# MDP23002-R2-MDDP.pdf Markup Summary

**Subject:** Callout  
**Page Index:** 5  
**Date:** 1/16/2024 10:15:57 AM  
**Author:** Jeff Rice - EPC Engineering Review  
**Color:** ■  
**Layer:**  
**Space:**  
**Page Label:** 5

EAGLEVIEW
EL PASO COUNTY, COLORADO
OVERVIEW MAP - PBMP TRIBUTARY AREAS

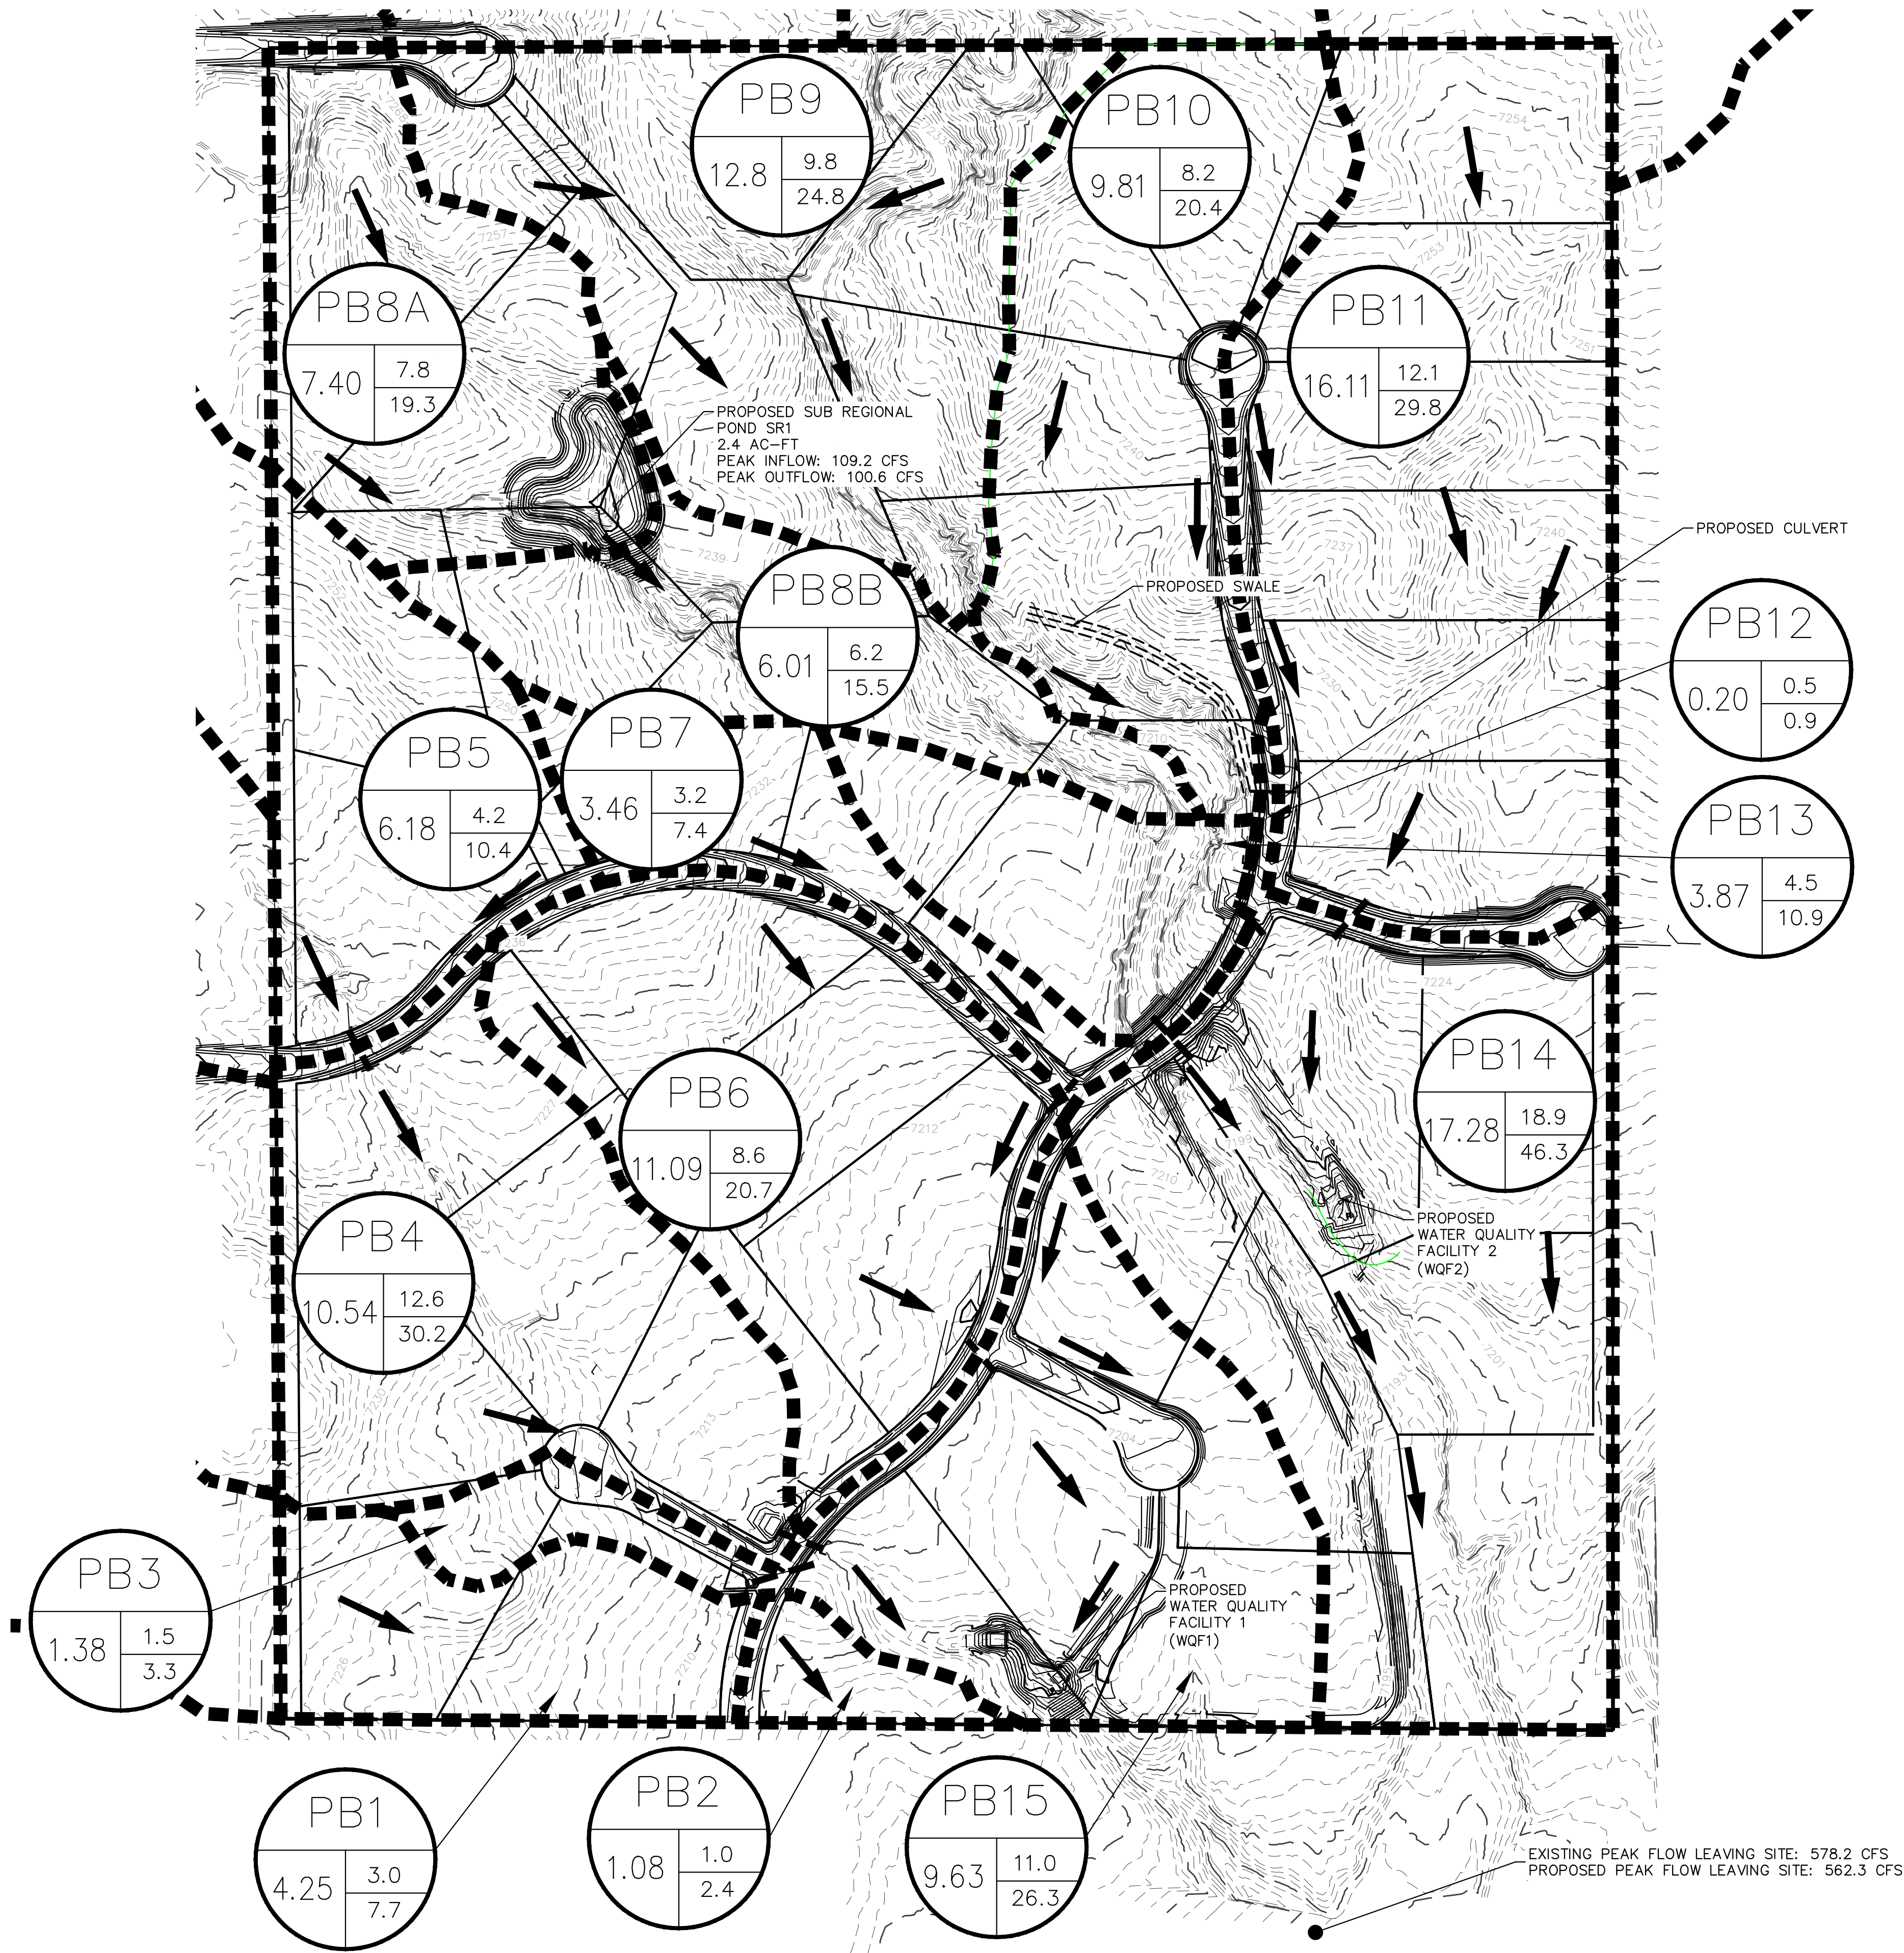
This ~0.52ac of roadway should also be shown as red and count towards the total excluded area.

Update total value per my comment above about the northwestern cul-de-sac

EAGLEVIEW
EL PASO COUNTY, COLORADO
PROPOSED CONDITIONS DRAINAGE MAP

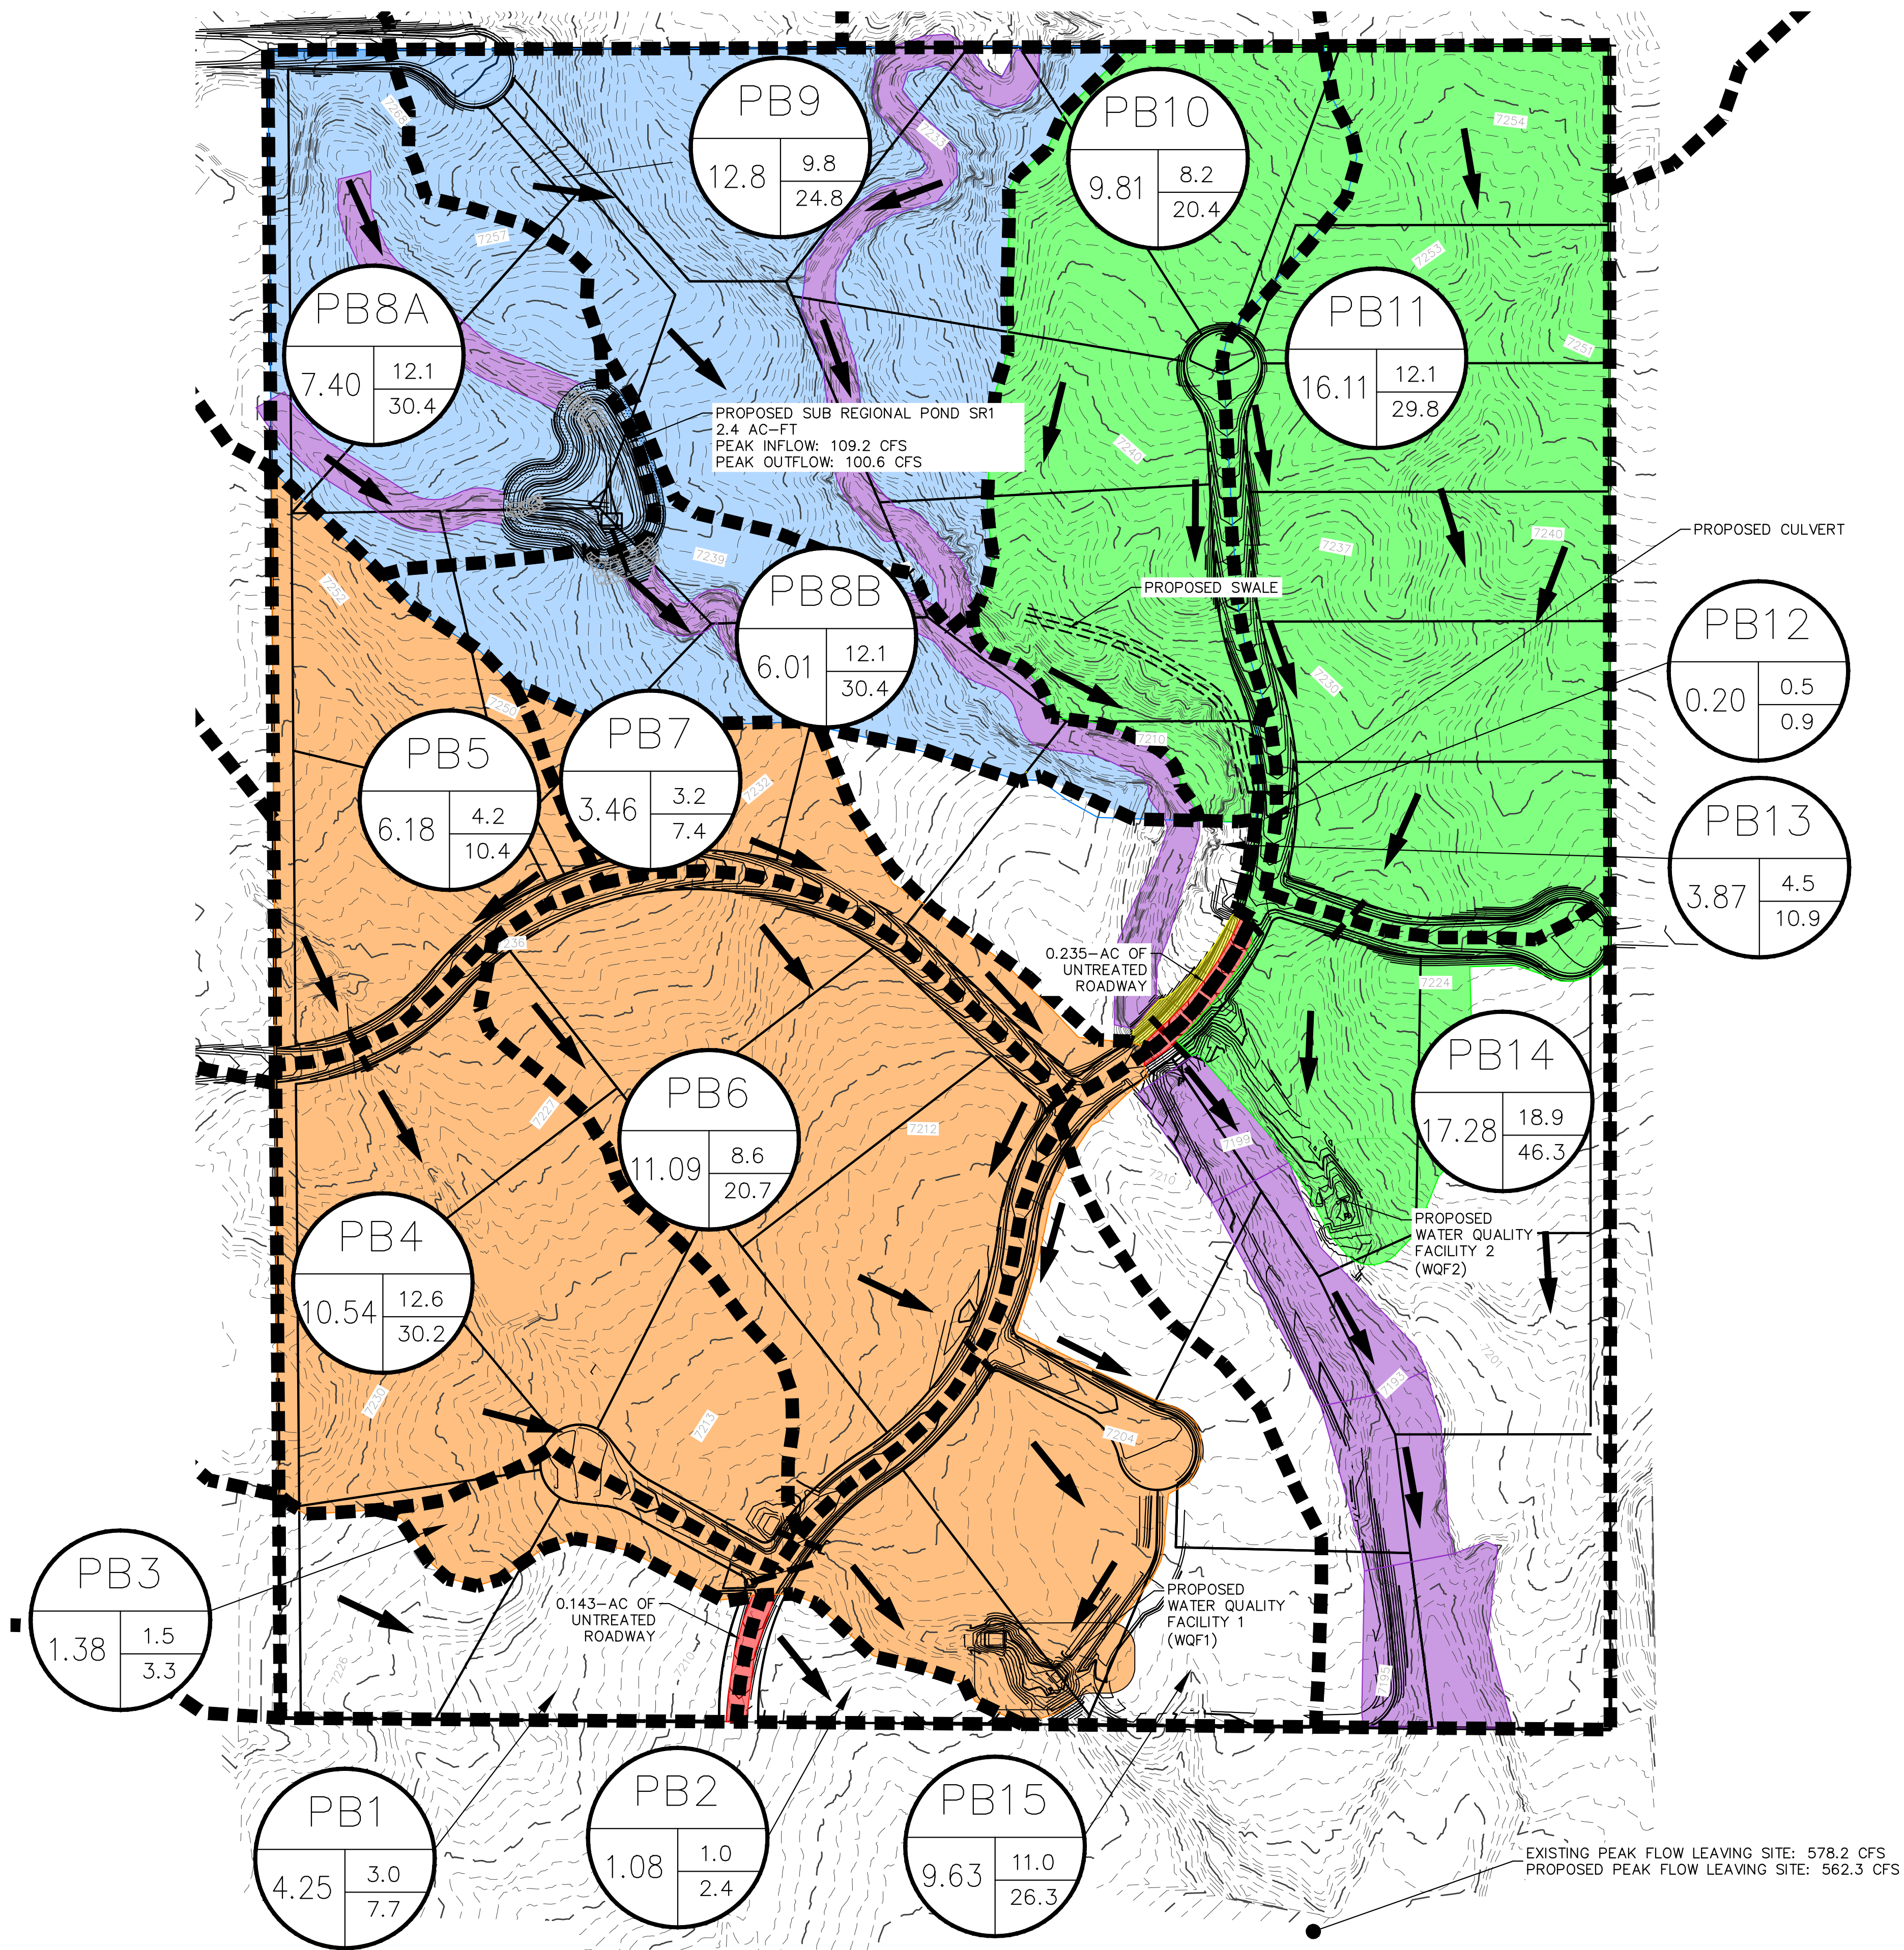
Note: The existing stock ponds need to be addressed in the FDR if they haven't been already. Show it on the drainage plans. Are water rights in place? Has embankment stability analysis and maintenance plan been completed if it is to remain?

SECTION A1 SHEET PILE CHECK

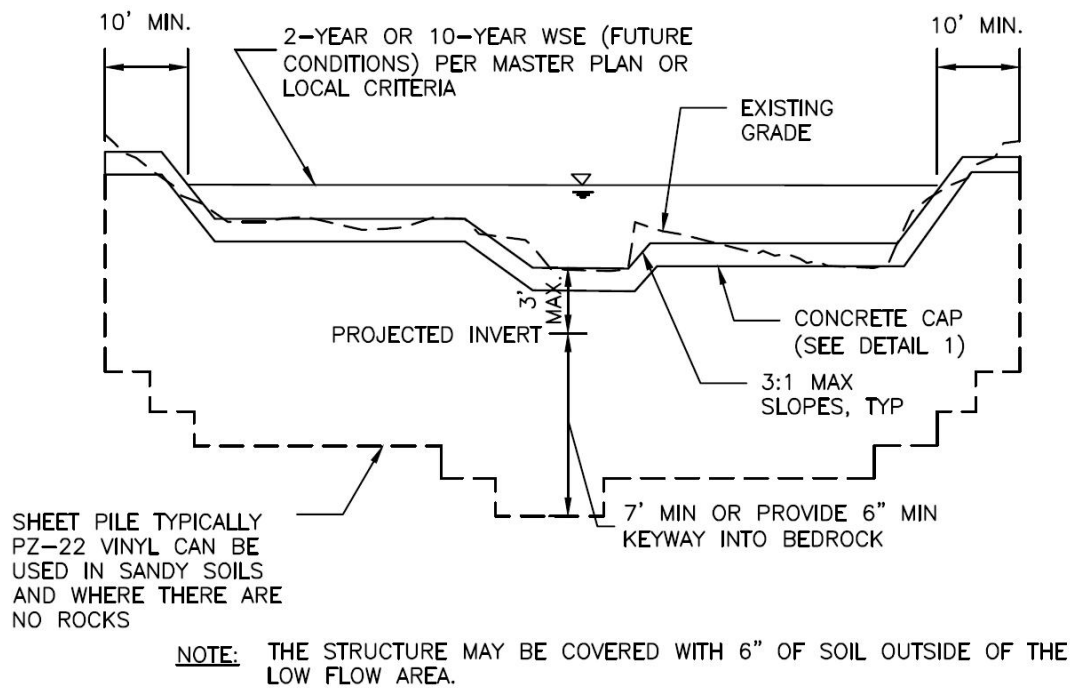
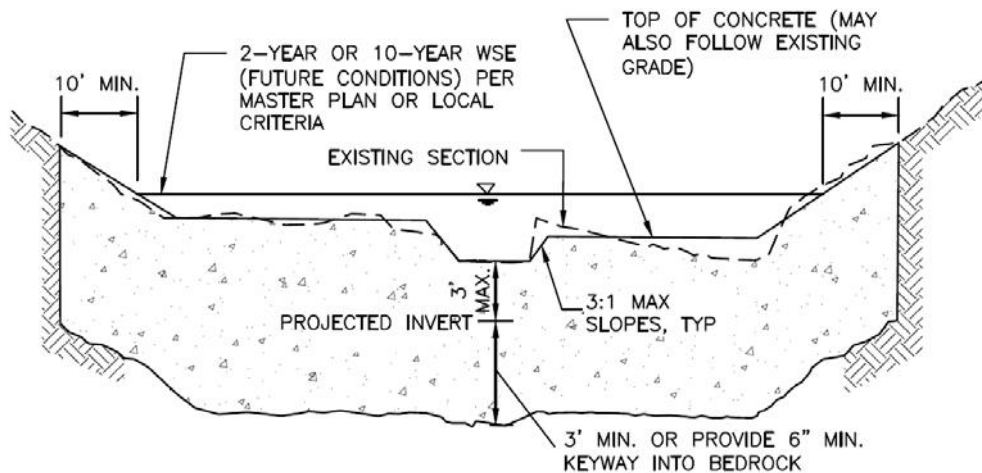
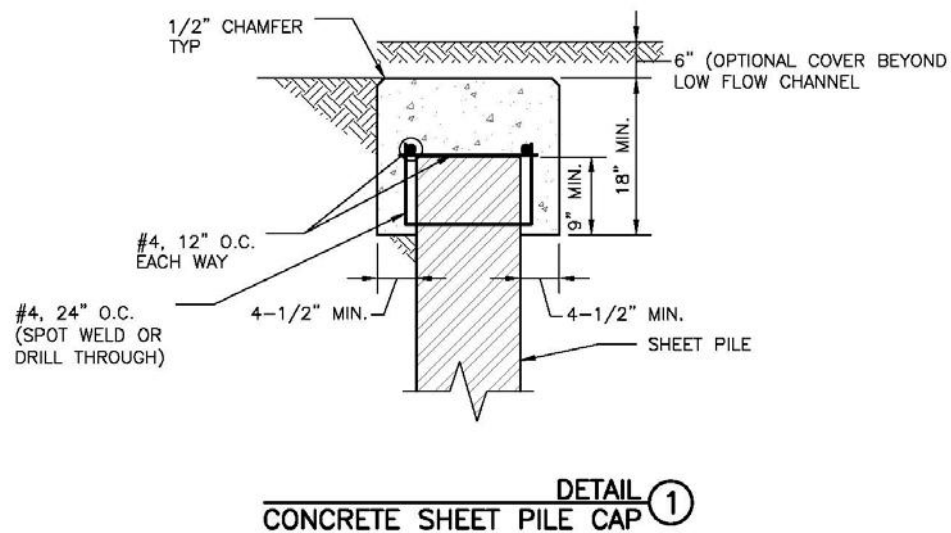
Verify whether concrete or sheet piles will be used
